# BICESTERBUG

## **Submissions on proposed Drive-Thru Outlet**

**21/02286/F**

**3 August 2021**

Figure 3.1 – Proposed Site Plan

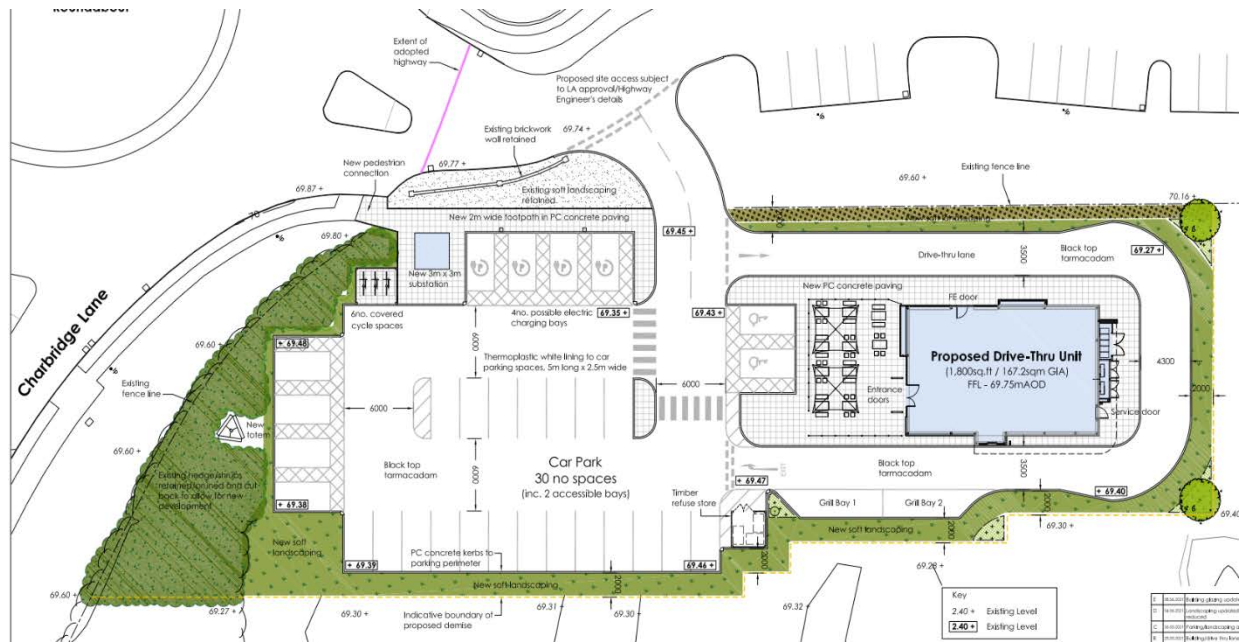
There is currently only one tolerable crossing over the Skimmingdish Lane, which is well away from the desire line and not well situated to benefit this development. It also requires most users to cross other arms of the roundabout where there are uncontrolled crossings. Most visitors are in fact likely to approach from the opposite direction, the industrial estate. Here there are a large number of units including educational facilities that are occupied during the day. Visitors to the proposed development would want to cross via the A4421 arm where there is presently only an uncontrolled crossing. In the absence of such provision, it is likely that visitors within a few hundred metres of the proposed development will choose to drive to access it, thereby choking the roads.

As confirmed by LTN 1/20, uncontrolled crossings will discourage the overwhelming majority of users (Table 10-2). There are uncontrolled crossings over the Launton Road arm; the A4421 arm; and the entrance to the care home. In order to provide access, at a bare minimum there needs to be active travel friendly crossings over the arms of the roundabout such as parallel crossings. Ideally, crossings should be provided over all arms to create a so-called 'Dutch' roundabout. This would provide a cost-effective and demand-sensitive means of access that would cause little or no delay to existing motor vehicles using the roundabout. It would also reduce unnecessary traffic.

In addition, there are currently only very narrow, shared, paths in the vicinity, and these are incomplete. In order to provide access, all paths should be upgraded to segregated provision, and paths should be provided along all the desire lines to enable pedestrian and cycle access from all areas of Bicester.

The bike parking is both insufficient and in an inconvenient place, it has been located on the other side of the car park, almost as far from the building as possible rather than directly adjacent as would be most convenient. Providing 6 spaces, which are also not suitable for non-standard bicycles (adapted, trikes, cargo bikes), is insufficient, this has already been seen at other such outlets in Bicester where, despite poor cycle access, customers and staff arrive by bike. A larger number of secure cycle spaces, which also would accommodate a diversity of cycles, should be provided.
